Your ref: EN010163

Applicant's response to request for information

The Applicant writes further to your letter of 6 August 2026 which set out the Secretary of State's request for further information (the "**RFI**"). The Applicant has considered the request and has set out its response below.

P22-1144_EN_27_B_01

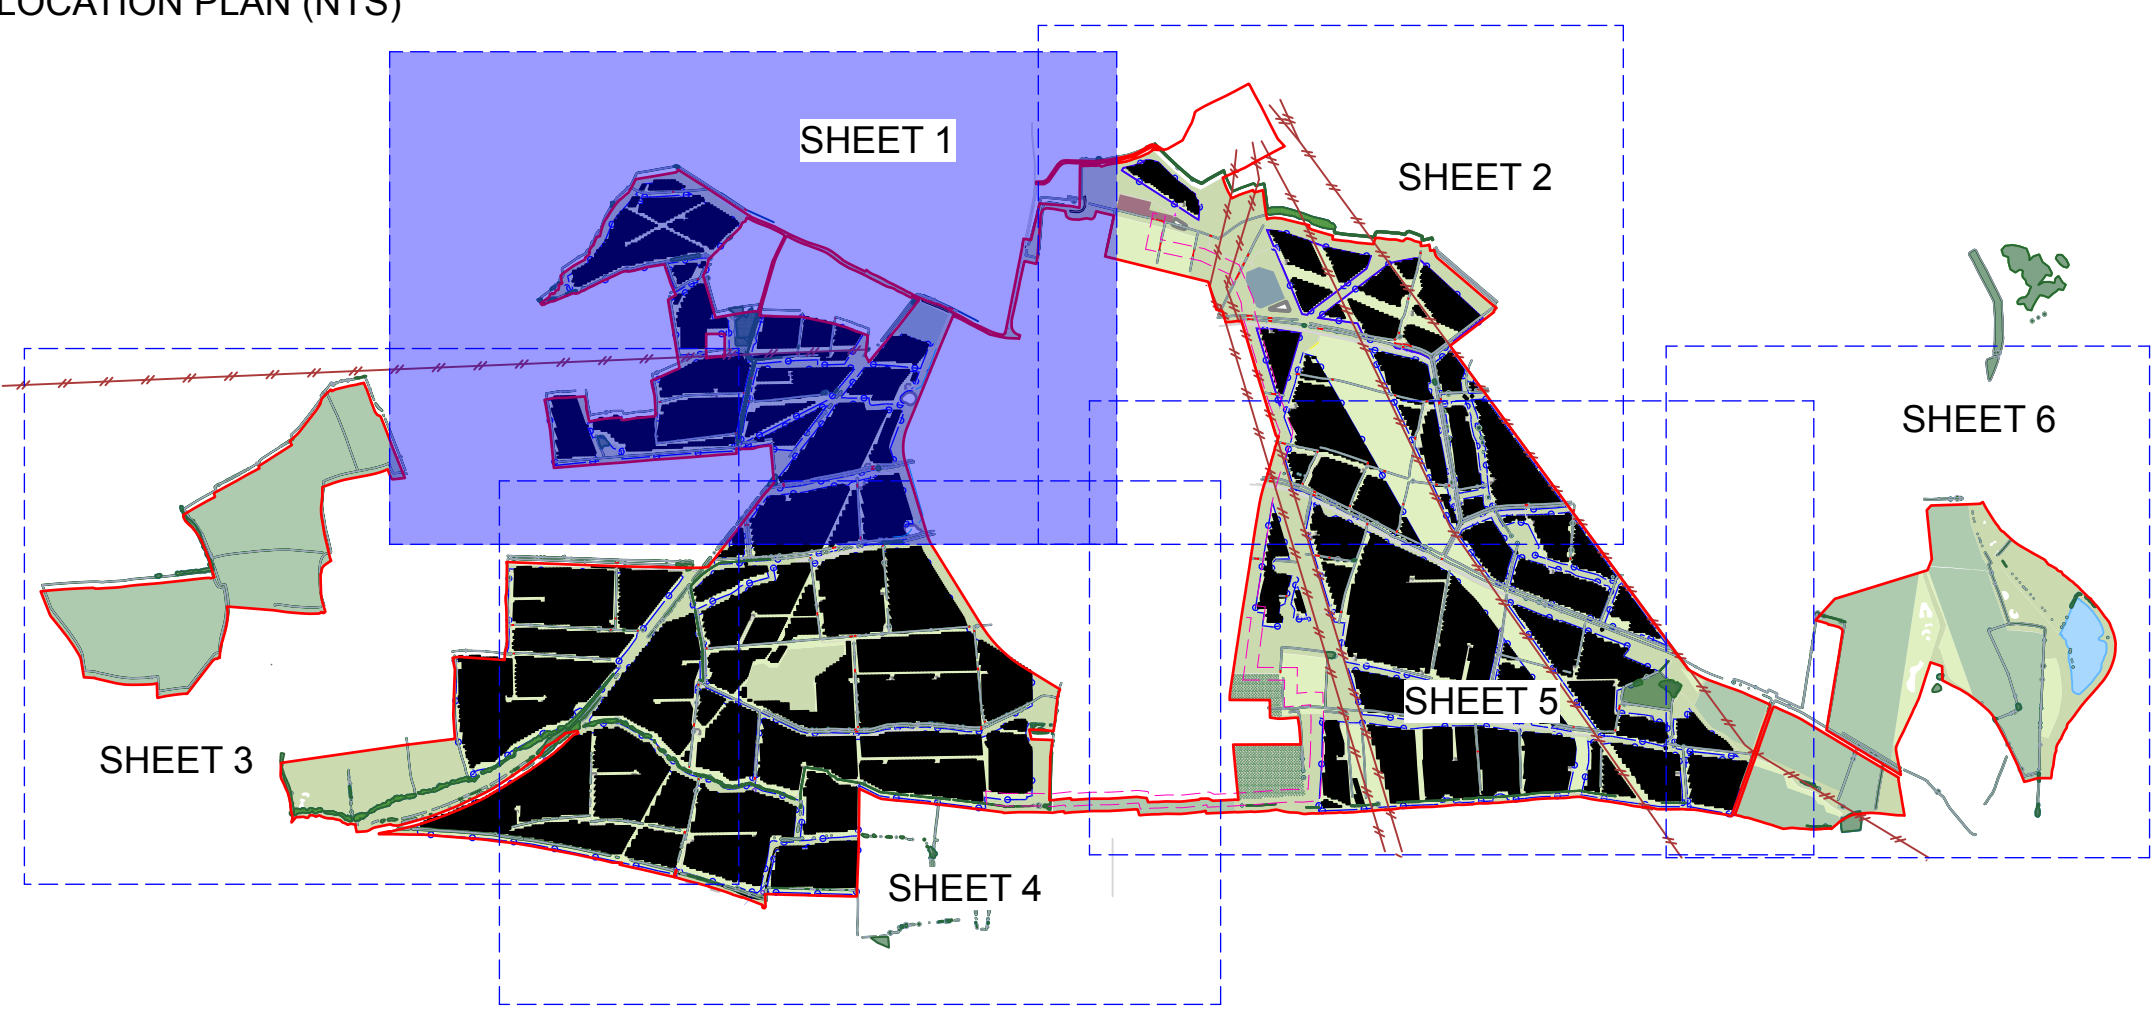
Paragraph 6 of the RFI requests the Applicant to update relevant documents to consider the feasibility of vegetation screening on the western side of the Battery Energy Storage System facility (BESS). Due to several constraints to the western side of the proposed BESS, which include two sets of existing overhead lines and a proposed cable route and associated easement, the Applicant has proposed vegetative mitigation along the boundary of the Order limits to provide screening of the western side of the BESS. These constraints can be seen on sheet 2 of the Works Plan [REP2-004] or equally sheet 2 of the Crossing Plan [AS-007]. This mitigation provides new hedgerow planting to the east of Sutton le Steeple footpath FP17 (Ref 123/17/2) and to the east of the settlement. The proposed hedgerow along the boundary of the Order limits connects with proposed Woodland Copse planting to the north-west (and to the north of the eastern sections of the settlement) and existing field boundaries to the west of the proposed BESS and north of Common Lane. This can be seen in the Landscape and Ecological Mitigation Strategy [APP-160] and it was this mitigation that was considered in the Environmental Statement: Chapter 6: Landscape and Visual Impact and Residential Amenity [APP-064]. The landscape and visual effects as set out in Chapter 6 would not change as a result of the addition of the hedgerow as shown on drawing number P22-1144_EN_27_B_01 (Sheet 2).

The Applicant has reviewed the margin between the fencing around the BESS and the access track further to the west against the required offsets for vegetation and BESS. Due to changes to design and safety constraints for offsetting vegetation from BESS, as set out by the National Fire Chiefs Council (NFCC) in their Battery Energy Storage Systems (BESS) Position Statement (October 2025), an additional proposed native hedgerow has been added to this margin in the updated Landscape and Ecological Mitigation Strategy (drawing number P22-1144_EN_27_B_01 (Sheet 2)) submitted alongside this letter. This proposed planting would provide additional close-range screening to the BESS compound and in particular the perimeter fencing on the western side of the facility.

This additional vegetation would contribute additional layering to the existing hedgerows and the proposed new hedgerow on the Order limits to the west of the BESS as described above. However, it is considered that, whilst this additional hedgerow would be beneficial, it would not in itself change any conclusions set out in the ES Chapter 6: Landscape and Visual Impact and Residential Amenity [APP-064]. This is because the existing hedgerow to the north of Common Lane is largely continuous with minimal gaps through which relevant receptors could gain full uninterrupted views of the western edge of the proposed BESS compound, and the existing proposals for mitigation along the Order limits function as intended to mitigate the visual impact of the BESS.

Whilst the new hedgerow proposed above does not result in a change to the conclusions set out in the Environmental Statement, it would be a proportionate inclusion in its landscape design, as it would provide an additional layering effect and would have the result of softening any peripatetic views of the BESS from Common Lane, or the adjacent settlement. Therefore, the Applicant has provided an updated Landscape and Ecological Mitigation Strategy submitted alongside this letter.
